East Anglia ONE North and East Anglia TWO Offshore Windfarms

Applicants' Comments on SASES' Deadline 9 Submissions

Applicant: East Anglia TWO and East Anglia ONE North Limited
Document Reference: ExA.AS-6.D10.V1
SPR Reference: EA1N_EA2-DWF-ENV-REP-IBR-001056

Date: 6th May 2021
Revision: Version 1
Author: Royal HaskoningDHV

Plate A25.5.2 Predicted Noise Levels East Anglia ONE North

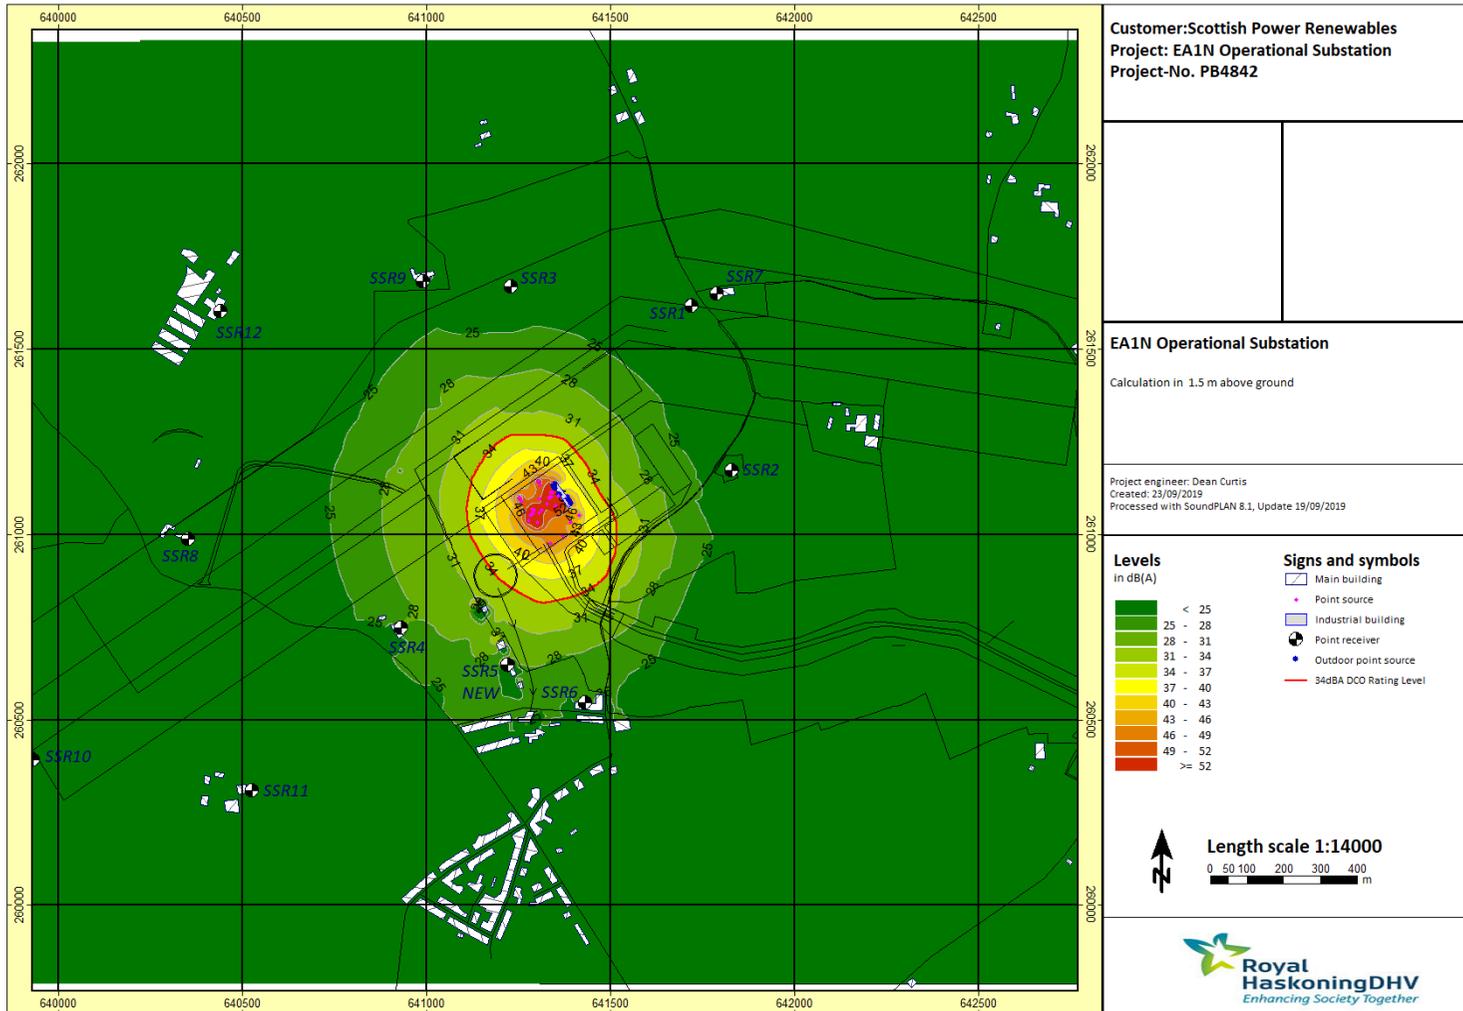
12	The Applicants have still failed to provide a logical reason for rejecting SSR9. They are proposing 31 dBA at SSR3. This will not be imperceptible, or even of reduced perceptibility in a background	The perceptibility of tones will depend on the prominence of any tone in relation to:

ID	SASES' Comment	Applicants' Comments
	<p>of 18 dBA. The ISO 226 threshold of audibility at 100Hz is 26 dB (unweighted, i.e. dBL, equivalent to 7 dBA), so at 31dBA the noise is well above threshold. Accordingly, there is no basis for rejecting a penalty for tonality based on the noise being imperceptible at the receptor.</p>	<ul style="list-style-type: none"> The overall level of sound emitted from the onshore substations from all the equipment, including several items of mechanical equipment known to emit broadband sound. Equipment such as the transformers and the shunt reactors, which are capable of emitting tonal sound, only represent a small proportion of the total number of individual items of equipment as demonstrated by Table 3 and Table 4 of the Noise Modelling Clarification Note (REP4-043); and The ambient sound level at the receiver location in which the sound will be perceived (mostly inside people's bedrooms in the middle of the night. <p>Section 6.3 of the Noise Modelling Clarification Note (REP4-043) provides information on the dominant noise sources. It shows that the relative sound contribution from the transformers is low compared to the total predicted noise level. It is worth noting that the Auto Transformer Coolers referred to are not the transformers themselves, but the mechanical cooling equipment associated with the transformers. This is the type of mechanical system that lends itself to conventional means of noise control (e.g. splitter silencers). It is also worth noting that the Harmonic Filters referred to are assumed to be in the open. This equipment can be enclosed if necessary. Because emissions from transformers represent a small contribution to the overall sound it is likely that any tonal components associated with the transformers will be significantly masked by emissions from other equipment.</p> <p>It is too simplistic to suggest that the perceptibility and audibility of the tones will depend on the difference between the rating level and the external background sound level and the threshold of audibility curves. Neither is such an approach consistent with BS4142:2014+A1:2019 which contains detailed procedures in Annexes C and D for the assessment of tonality and the scale of any corrections to be applied.</p>

Figure: 29.37e
Viewpoint 5: Public Right of Way, near Moor Farm

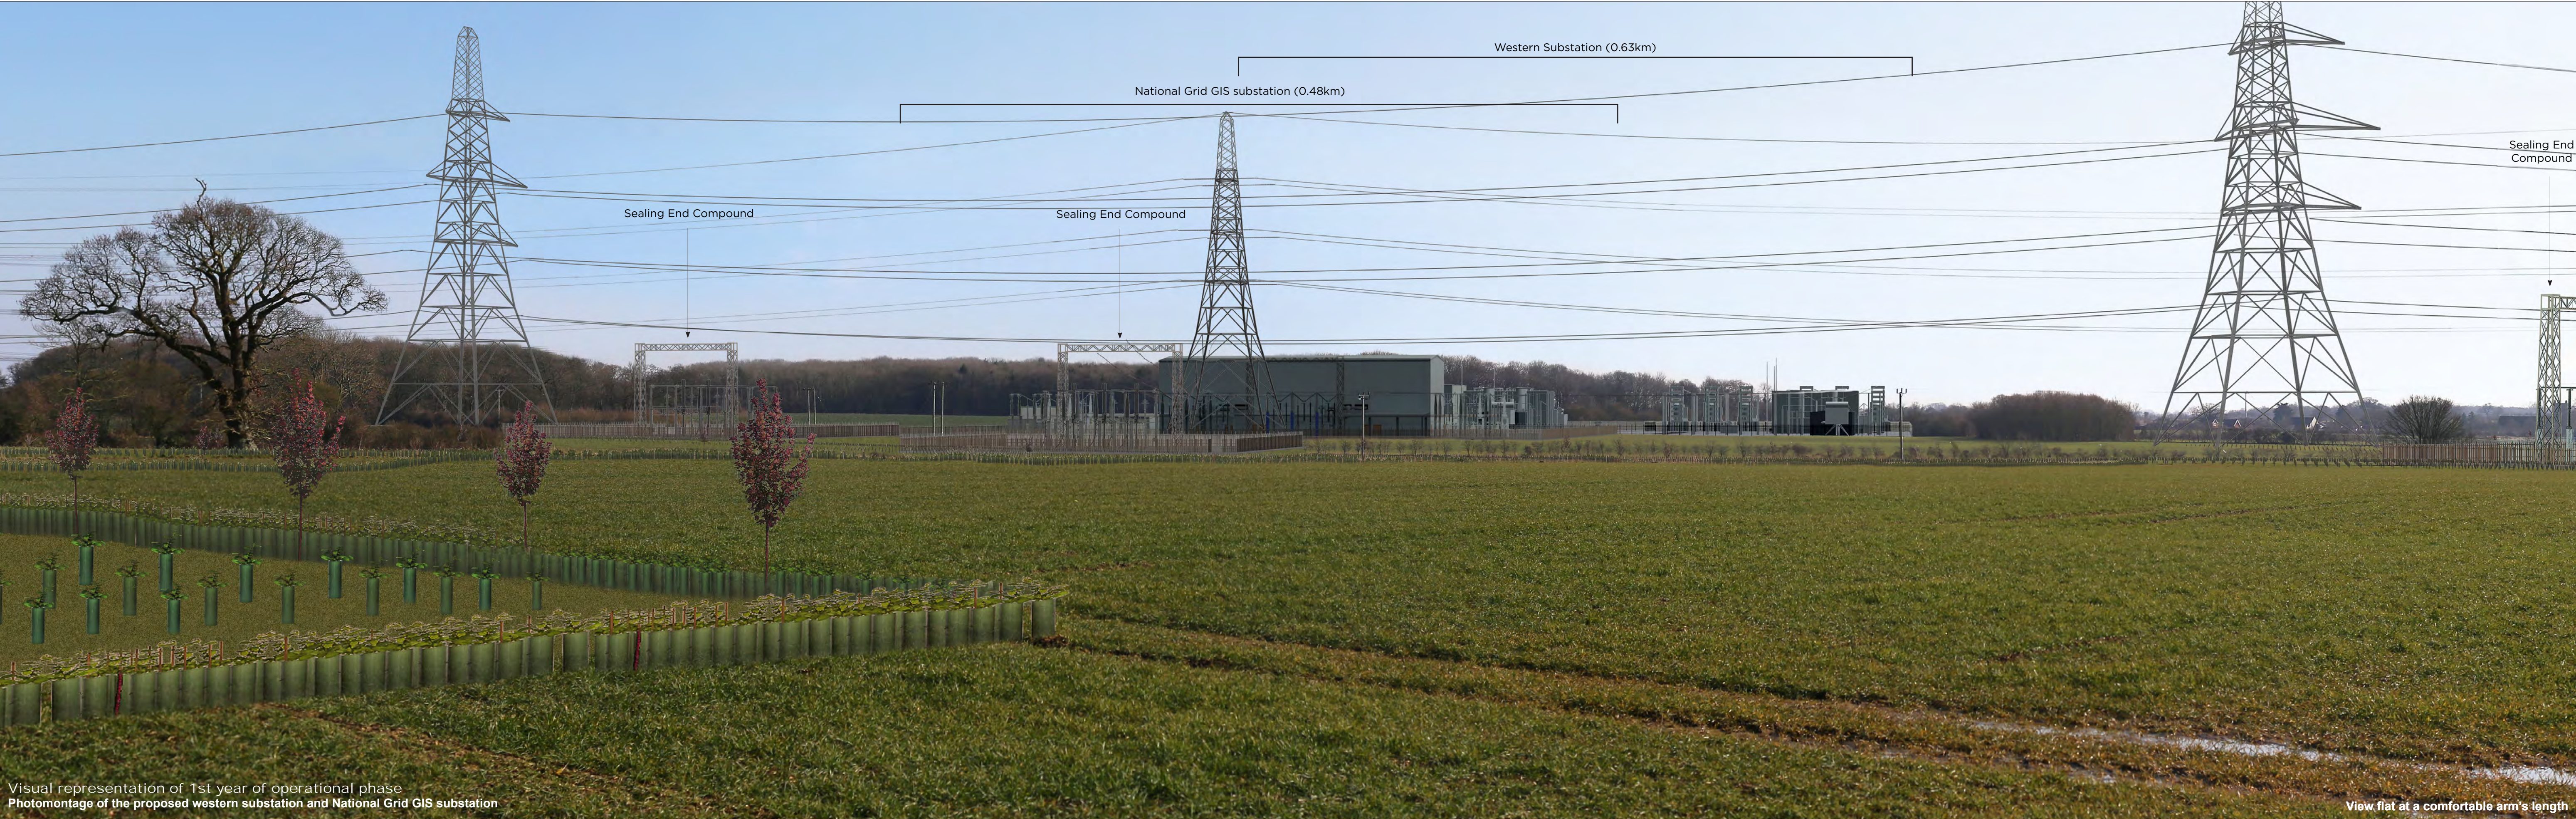
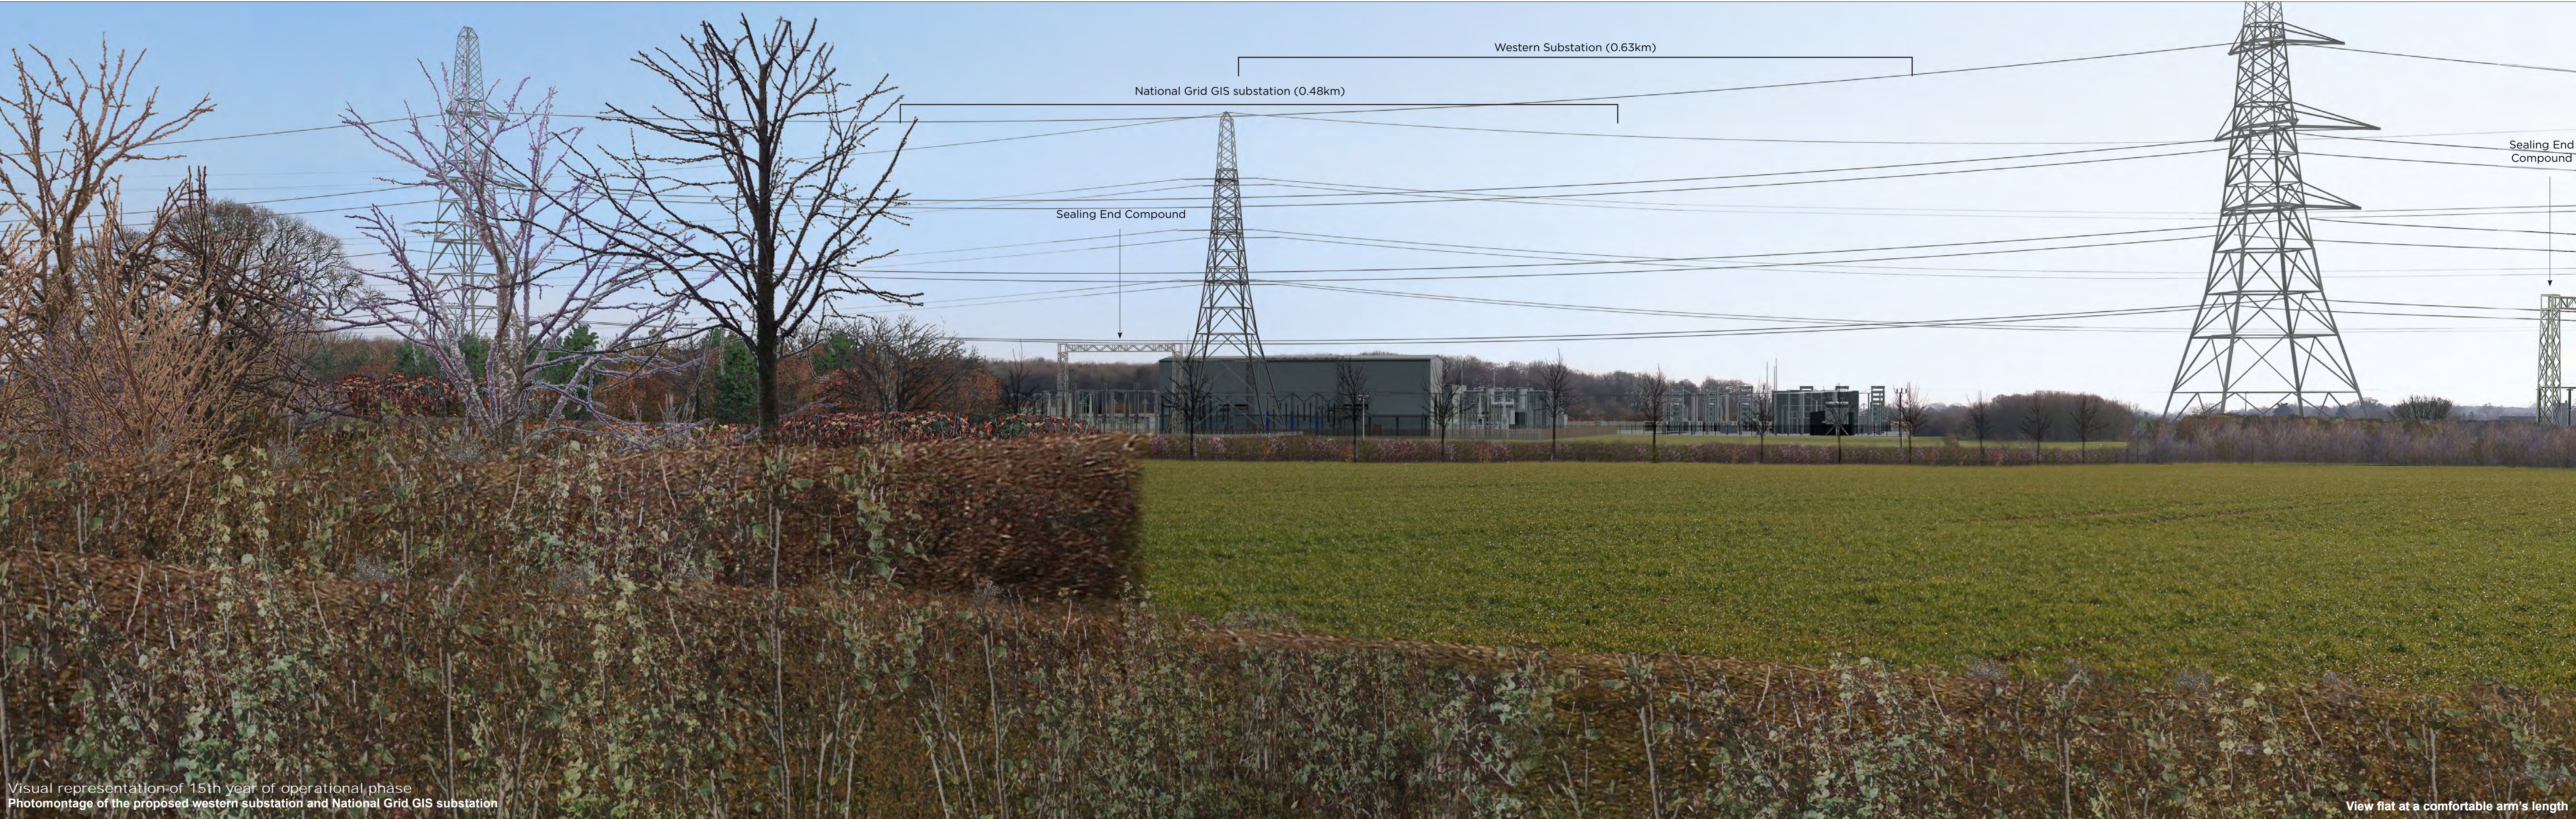
ID	SASES' Comment	Applicants' Comments
		and the significant landscape and visual effects already assessed for the Projects at the local level.
34	<p>The Photomontage from LVIA Vp 5 shows that the western NG extension would 'fill' the area between the western substation and the sealing end compound, where the additional pylon is located. This would solidify the extent of the industrial landuse across the view. It would sever any possible remaining visual connection with Friston Church and the edge of Friston. Any remaining appreciation of the relationship between the village and the wider landscape would be lost.</p>	<p>The Extension of National Grid Substation Appraisal (REP8-074) acknowledges that the western potential future extension would be most readily visible extending the influence of development in the view south from Viewpoint 5 towards Friston. Comparison of the original photomontage from Landscape and Visual Impact Assessment Addendum - Appendix 5 - Viewpoint 5 (REP4-036) with the Photomontages with Potential National Grid Extensions Bays (REP8-071 – REP8-073) shows that the western extension would largely be located in line with and reinforce the massing of elements within the National Grid substation and western onshore substation. Although it also results in some westwards extension of structures towards the overhead pylon, the edges of the village of Friston will be visible beyond and through the intervening but permeable structures such that the church and village remain legible.</p>
